Deadline 2 submission for Bramford to Twinstead (EN020002)

1.1 This is the joint deadline 2 submission of Babergh District Council and Mid Suffolk District Council

STOUR VALLEY EAST  
 CABLE SEALING END  
 COMPOUND AT LITTLE  
 CORNARD

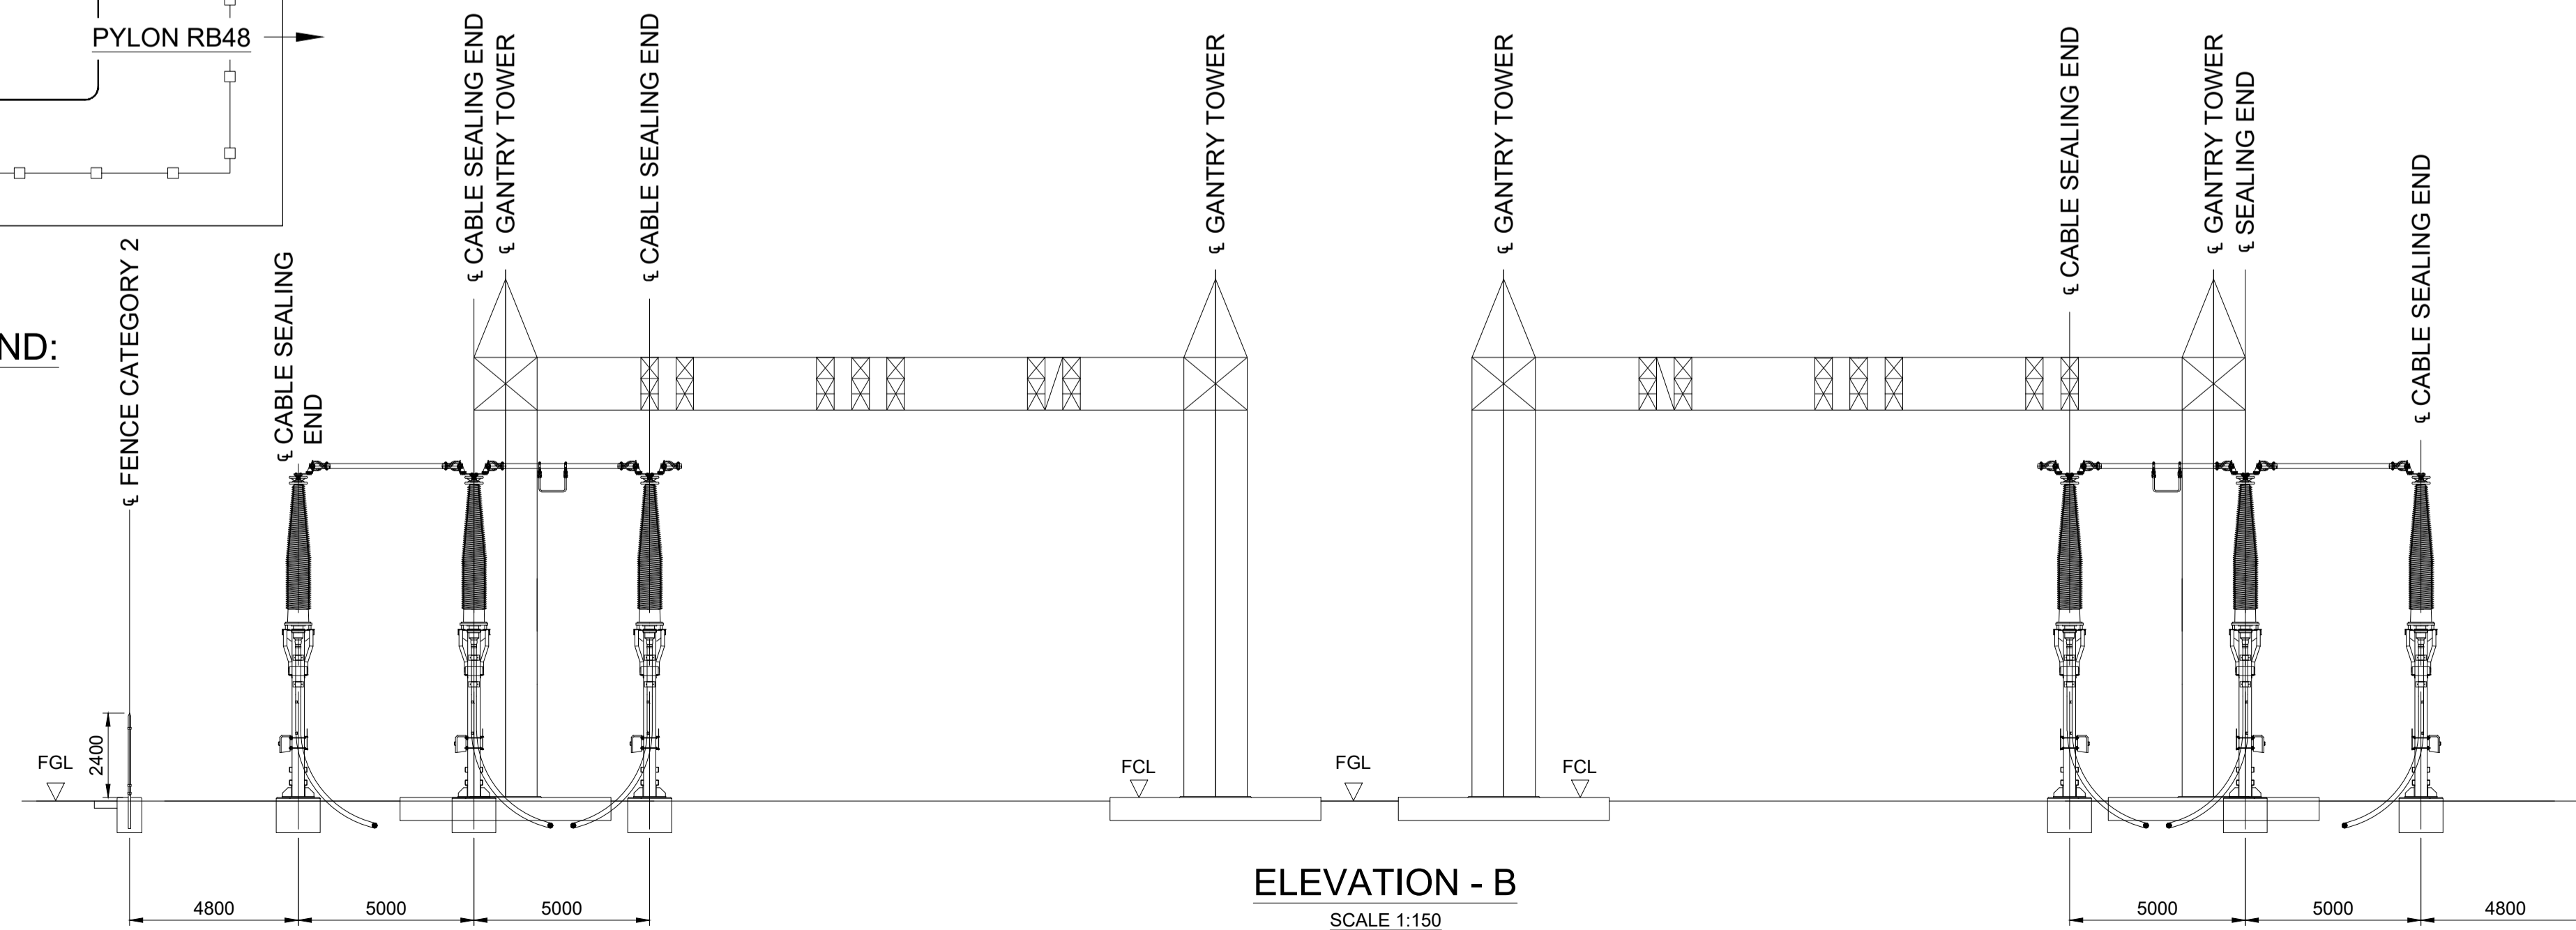
4.4 Additionally, it is suggested a closer viewpoint assessment and photomontage is needed for the Stour Valley East Cable Sealing Compound. The current photomontage from VP G2.5 is around 1.8Km away to the southwest and does not demonstrate the effects on the recreational receptors of the local footpath network.

- 4.10 BDC welcomes the additional undergrounding in the Stour Valley. The Council retains concerns that the assessment of the Stour Valley East Sealing End Compound has been considered at some distance from the facility therefore does not fully consider the experience of sensitive receptors using the PRoW network close by. As a result, there are concerns that any proposed mitigation or compensation will be insufficient to offset these anticipated adverse effects. BDC would like to see further assessment carried out from the PRoW network close to the facility and provision of a demonstrably effective mitigation and/or compensation scheme.
